2191002

Response to Request for Information for Eastern Creek Quarter - Lot 3 Concept Plan (SSD-10457)

Title
**INTERSECTION LAYOUT-CONCEPT
LINEMARKING PLAN,**

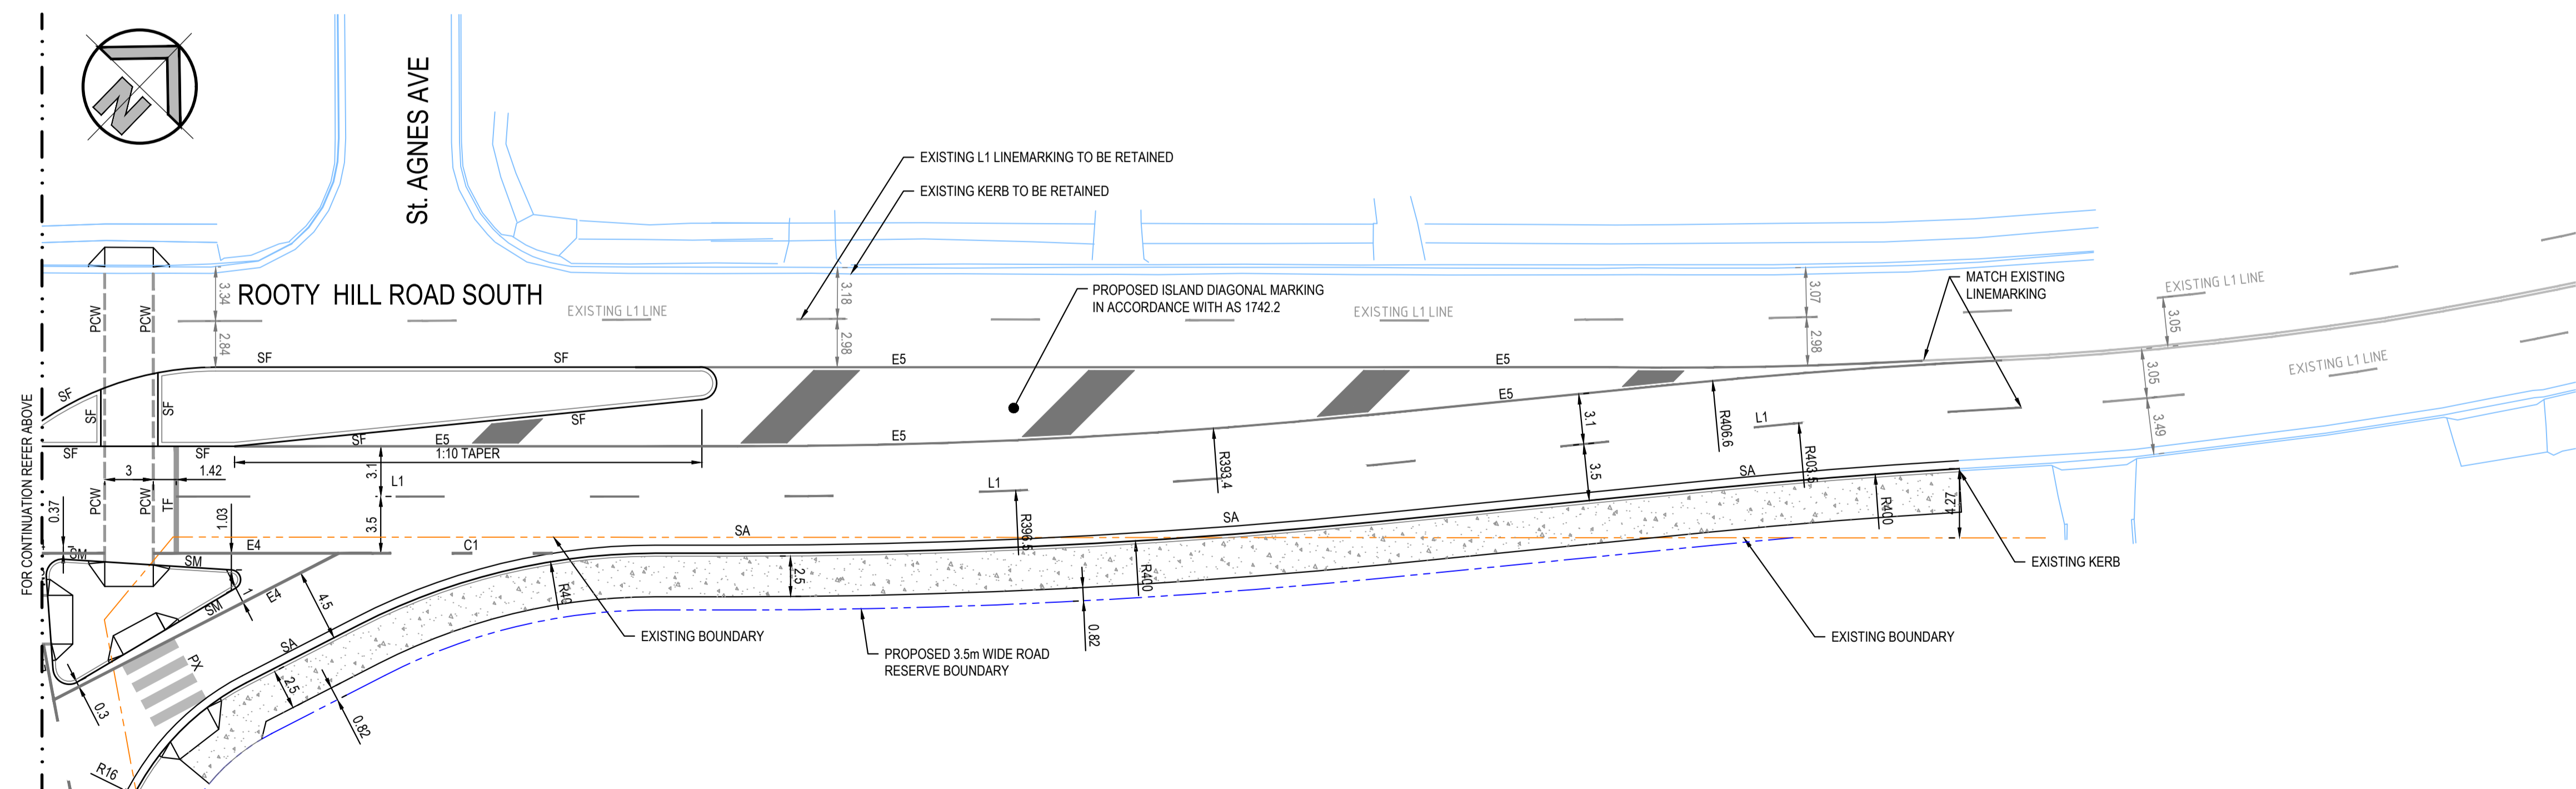
Matter raised	Response
TfNSW Submission	
The proposed length of the northbound right turn bay in the draft design is inconsistent with the SIDRA model. The proposed right turn bay should be amended to adequately accommodate right turning vehicle queuing without impacts on the operation of through traffic lane. The traffic model should be updated with the correct inputs to correct this.	CBRK has advised that the amended concept design (Attachment A) shows a right turn bay with storage of some 40 metres. The SIDRA analysis shows a 95% back of queue of some 30 metres. Accordingly, the right turn bay can accommodate turning traffic without impacting on the adjacent through lane.
It is noted that if the right turn bay is extended then the design will impact on the intersection of Beggs Road.	CBRK has advised that the traffic movements to/from Beggs Road are left in/left out. A minor change has been made to the concept design intersection of RHRS/Beggs Road (Attachment A) to accommodate the left turn into Beggs Road by a 19m articulated truck.

The width of 2.8m for the proposed northbound right turn lane is not acceptable to TfNSW. The design of the right turn lane should be in accordance with AUSTRROADS GUIDE TO ROAD DESIGN and other Australian Codes of Practice.	CBRK has advised that the width of the right turn bay has now been increased to 3.2M. This width is consistent with the right turn bay used in Cable Place. A slight reduction to the lot boundary has been made to allow for this additional space and an amended Plan of Subdivision can be provided to DPE once the concept has received in-principal support from TfNSW.
All lane widths in the design need to be identified (for new and existing).	This information is now included in the revised concept drawings.
The design speed must be 70km/hr to cater for a posted speed limit of 60km/hr.	CBRK has advised that radius of kerbs are all compliance with AUSTRROADS GUIDE TO ROAD DESIGN at Lot 3 boundary to Beggs Road is R107. It is requested that TfNSW confirm if there other specific elements which do not comply with a 70km/h design speed. It is considered that this is a matter which could be addressed as part of the future detailed design process.

INTERSECTION LAYOUT - TURNING PATHS

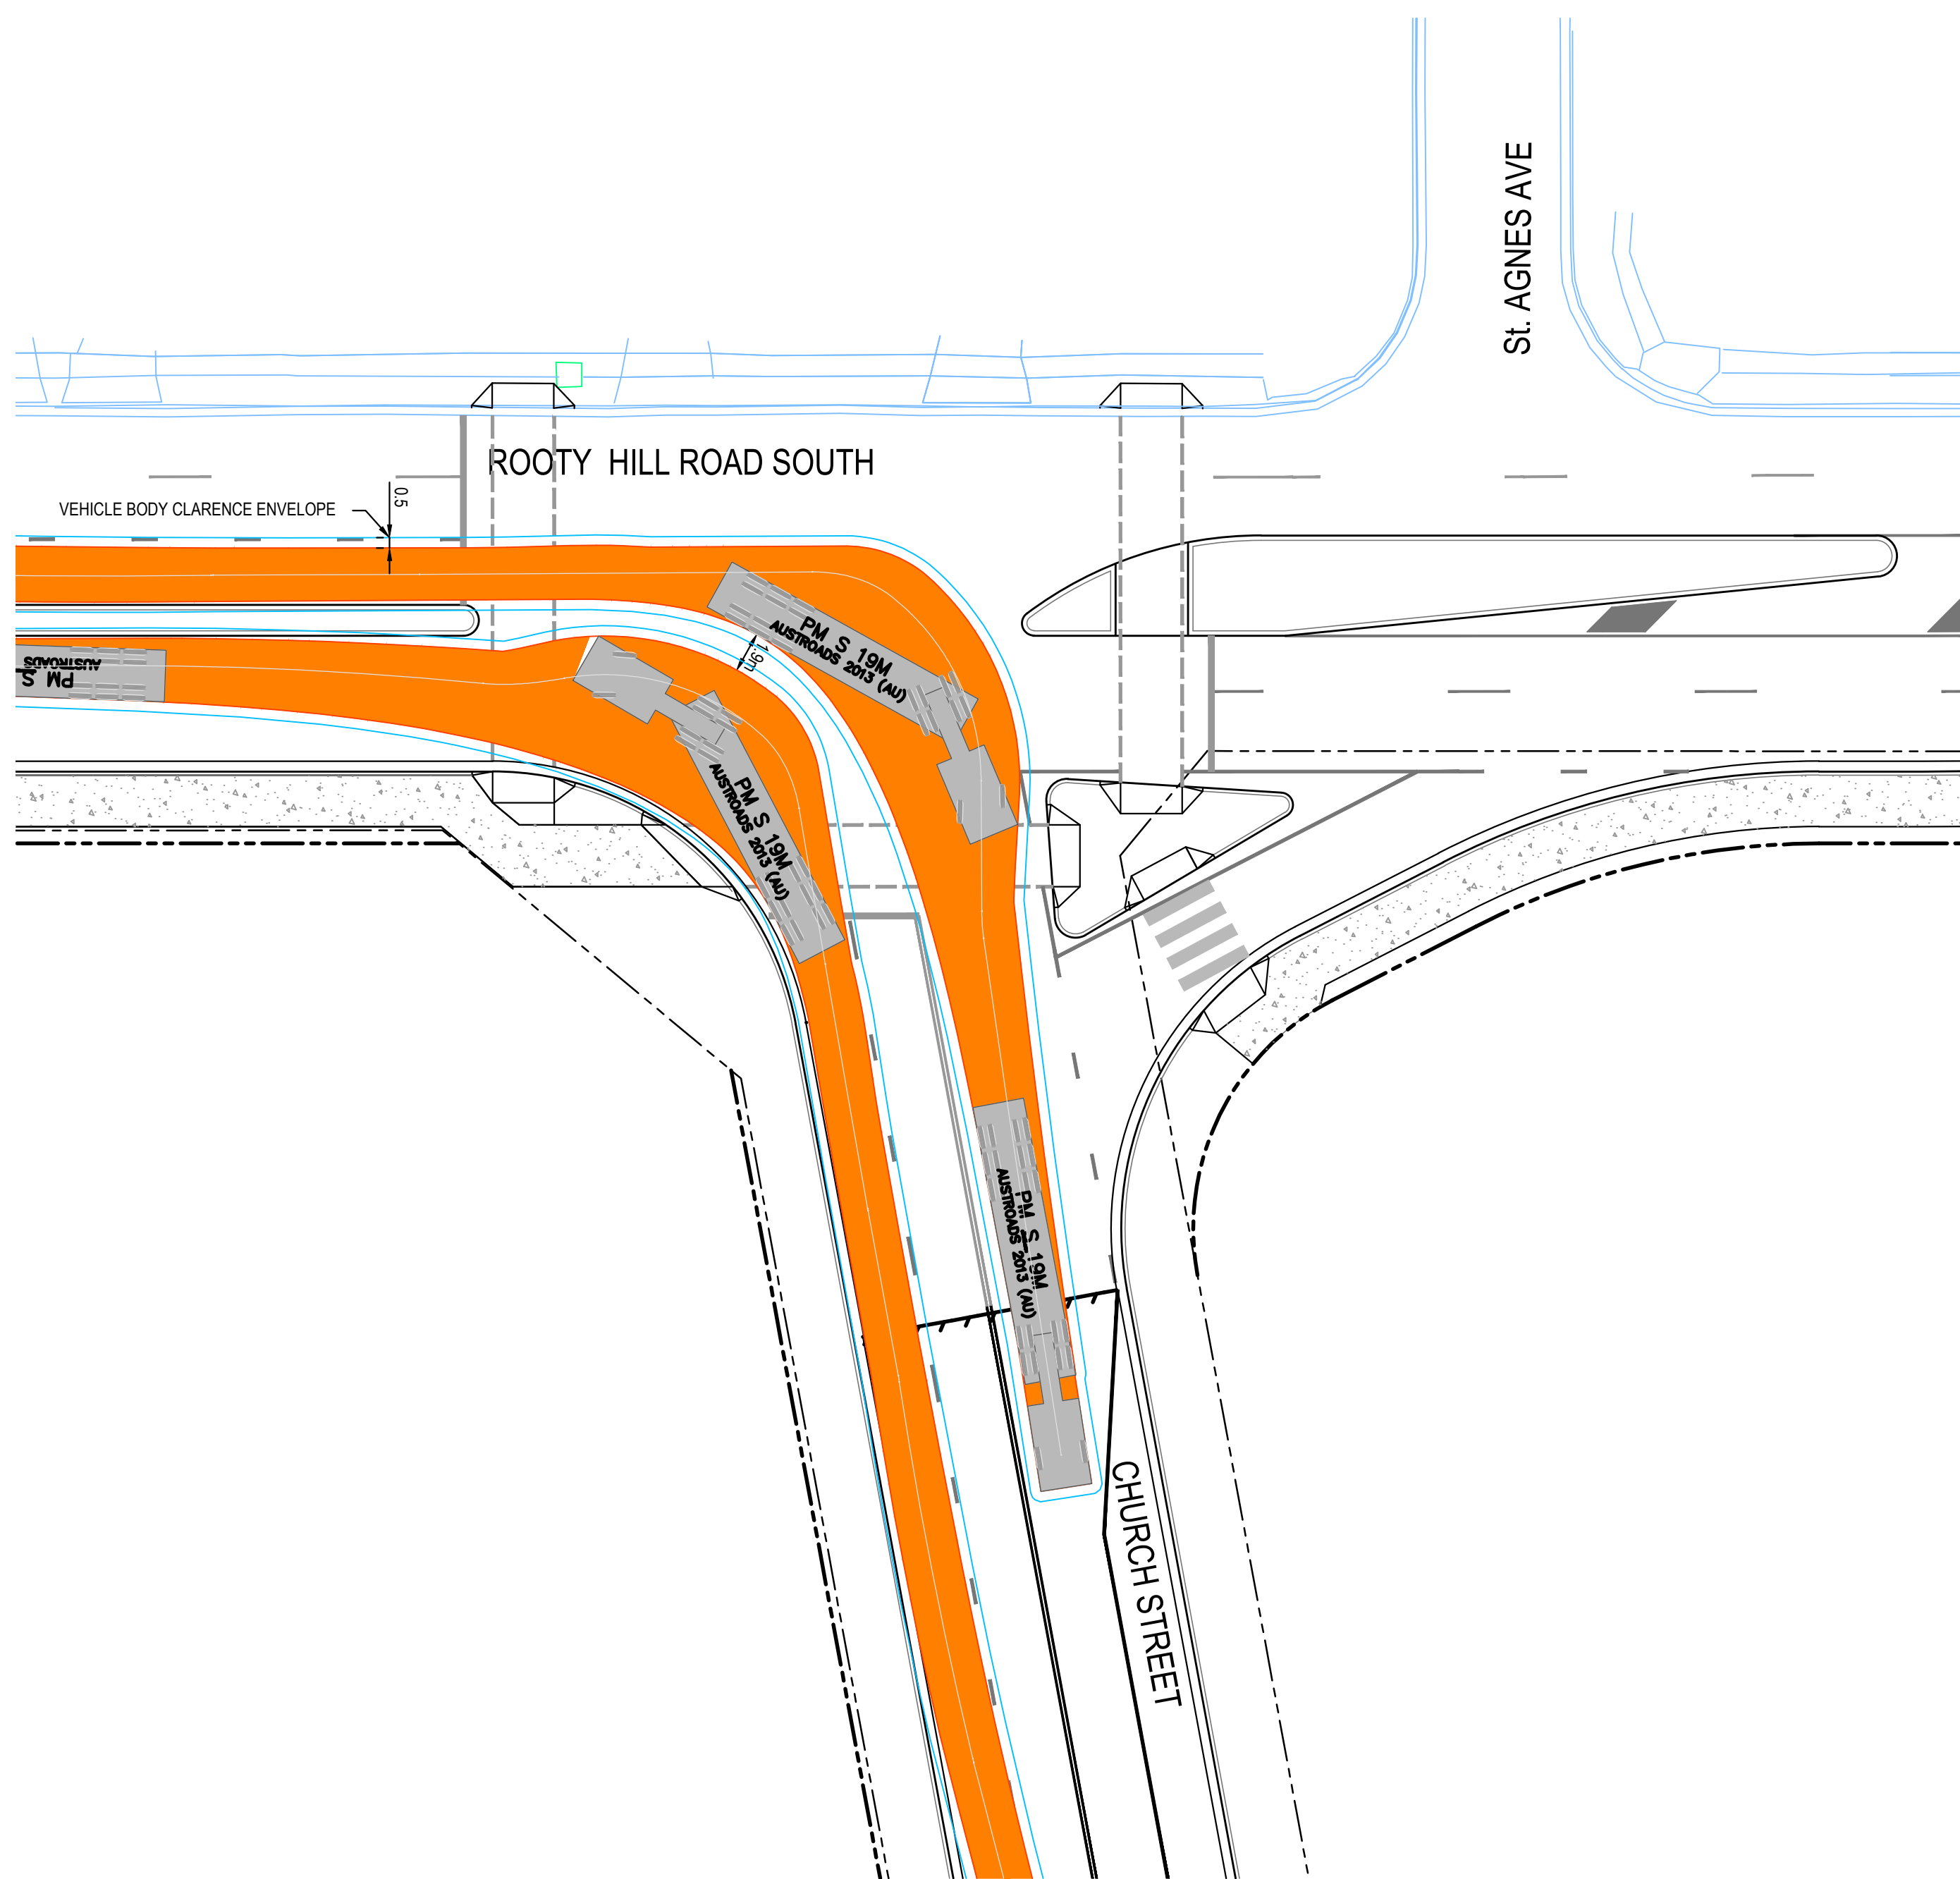
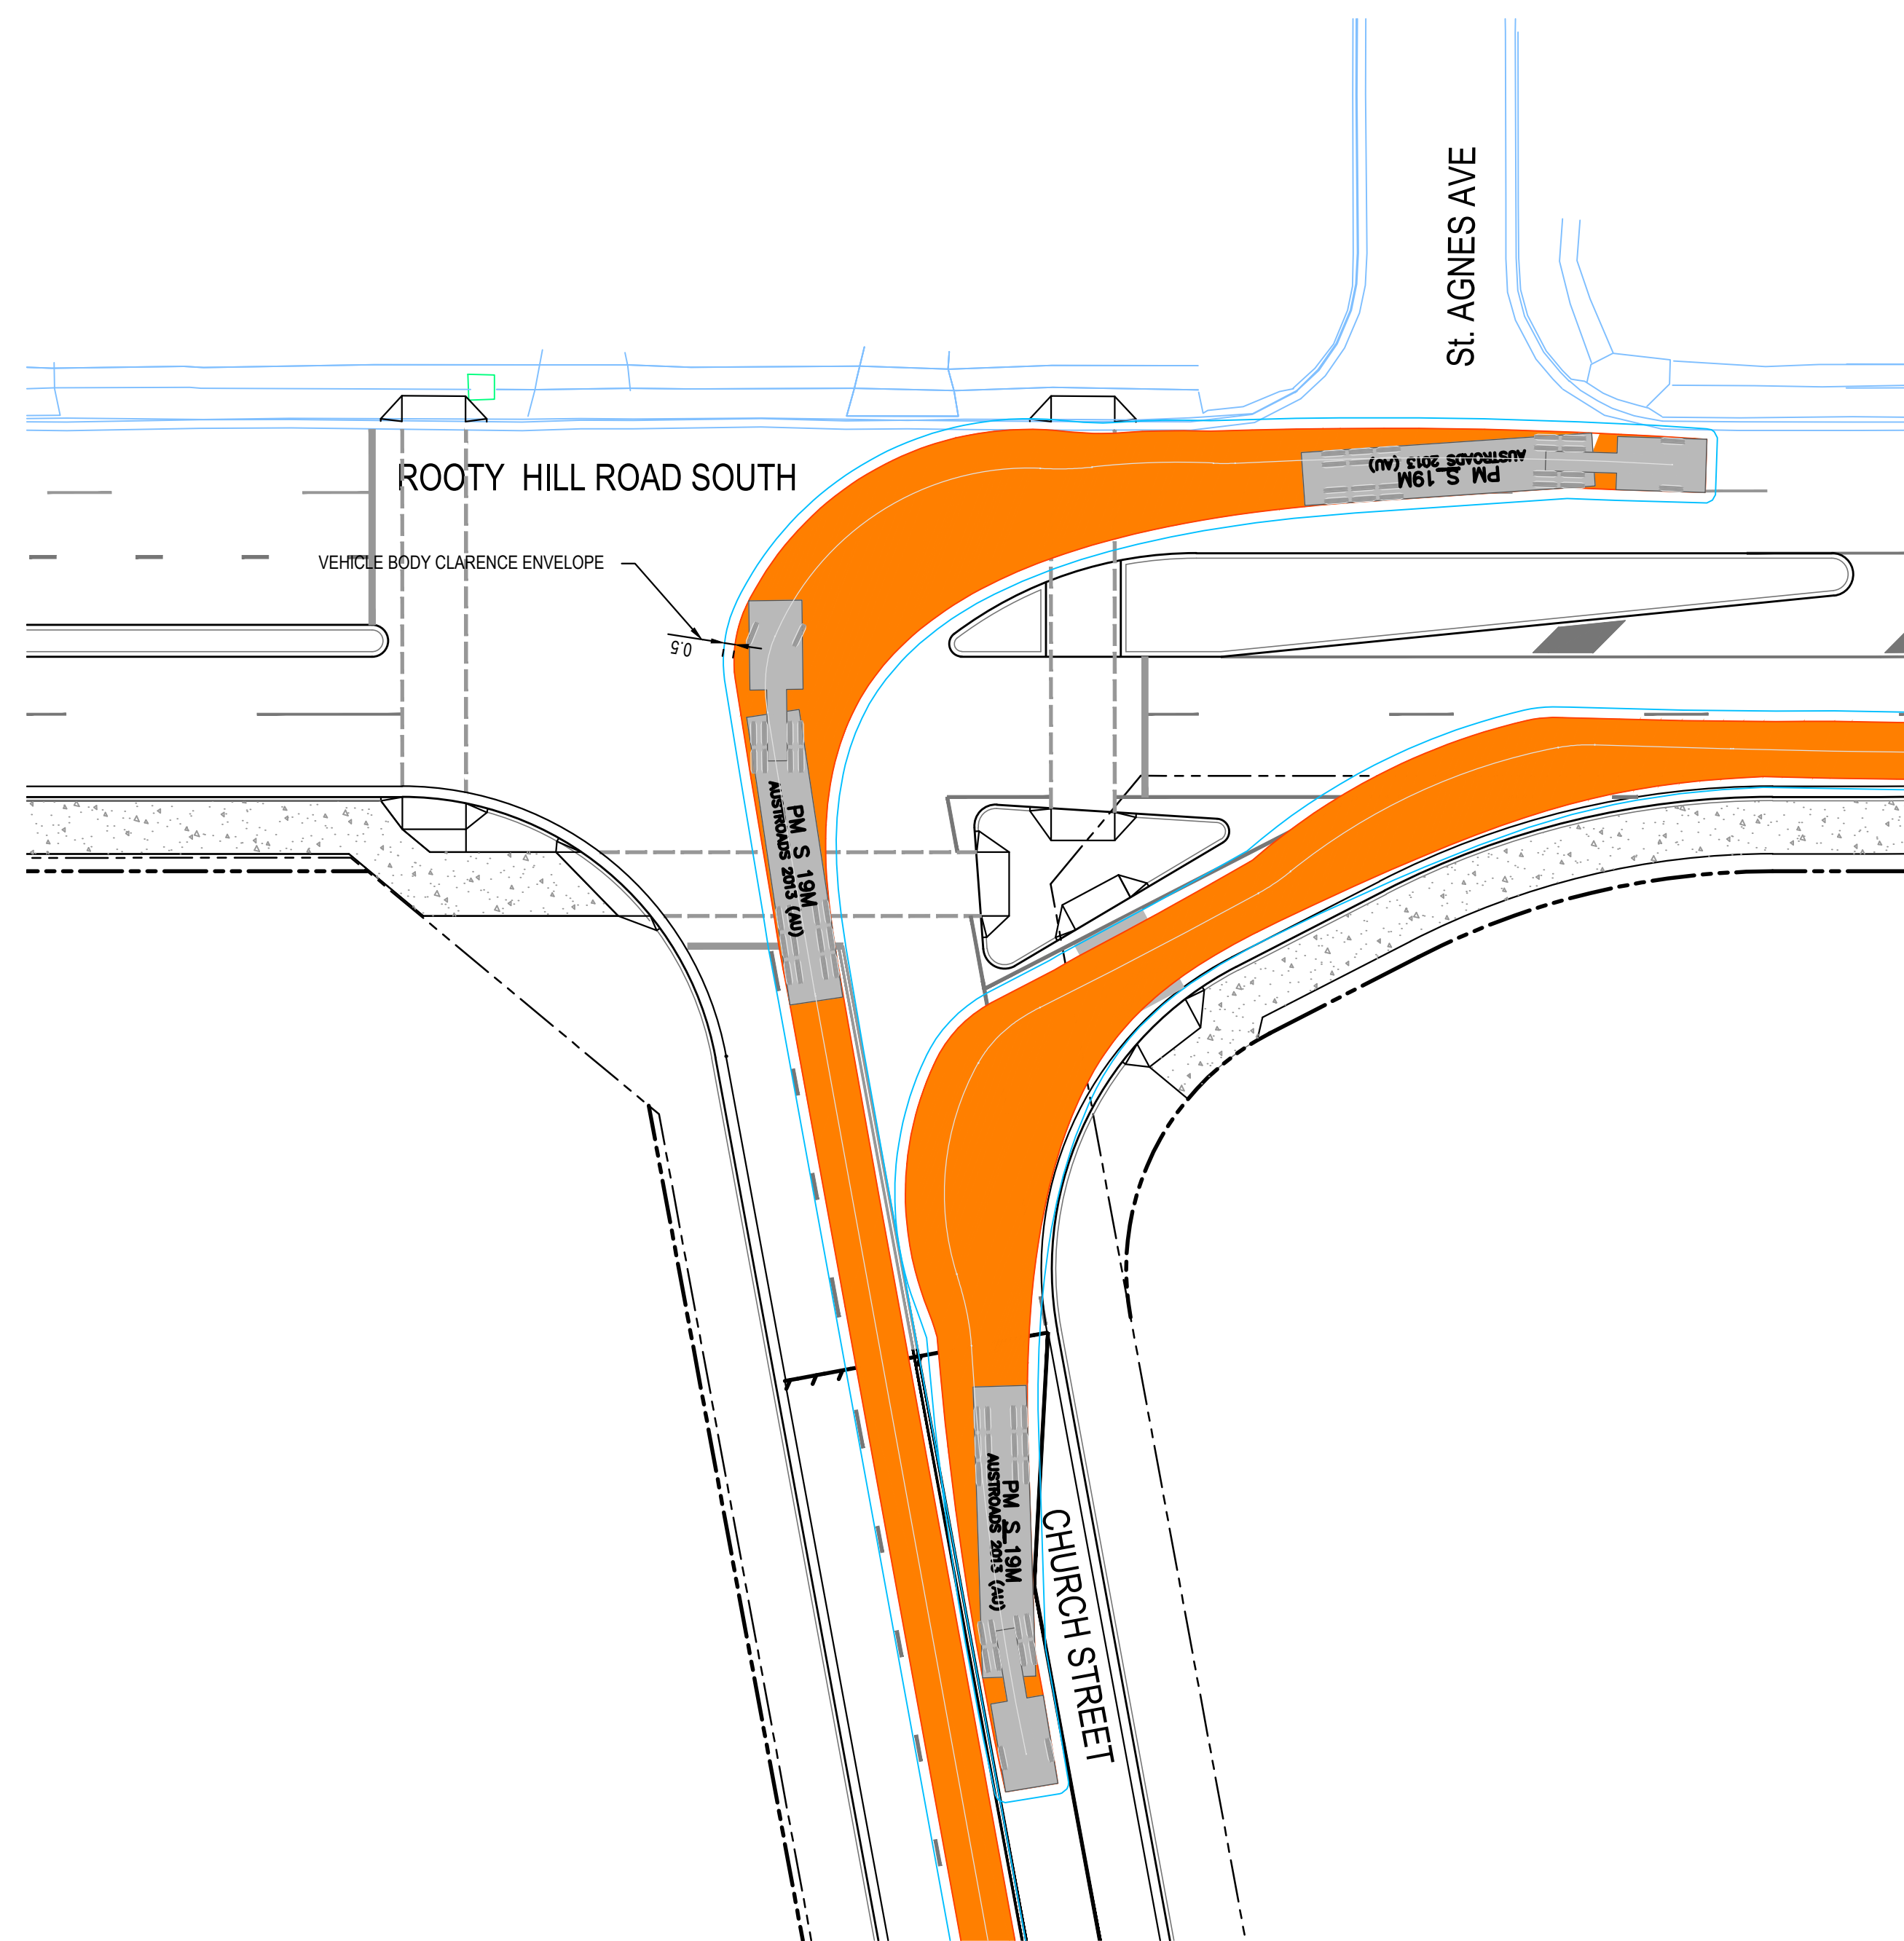
Concept civil design plans, swept paths and a draft Traffic Control Signal (TCS) plan of the proposed Rooty Hill Road South /Church Street intersection need to be submitted to TfNSW for review and approval.	Amended concept civil design plans and swept paths are included at Attachment B . CBRK has advised that a traffic control signal plan and detailed design is typically addressed at a the detailed design and WAD stage (as for the previous Cable Place works). Accordingly, this can be further addressed as part of the detailed design SSDA.
The applicant and Council could consider moving this proposed signalized intersection to the north for a 4 way	Movement of the proposed intersection to align with St Agnes Street would result in more than 3,000 sqm of
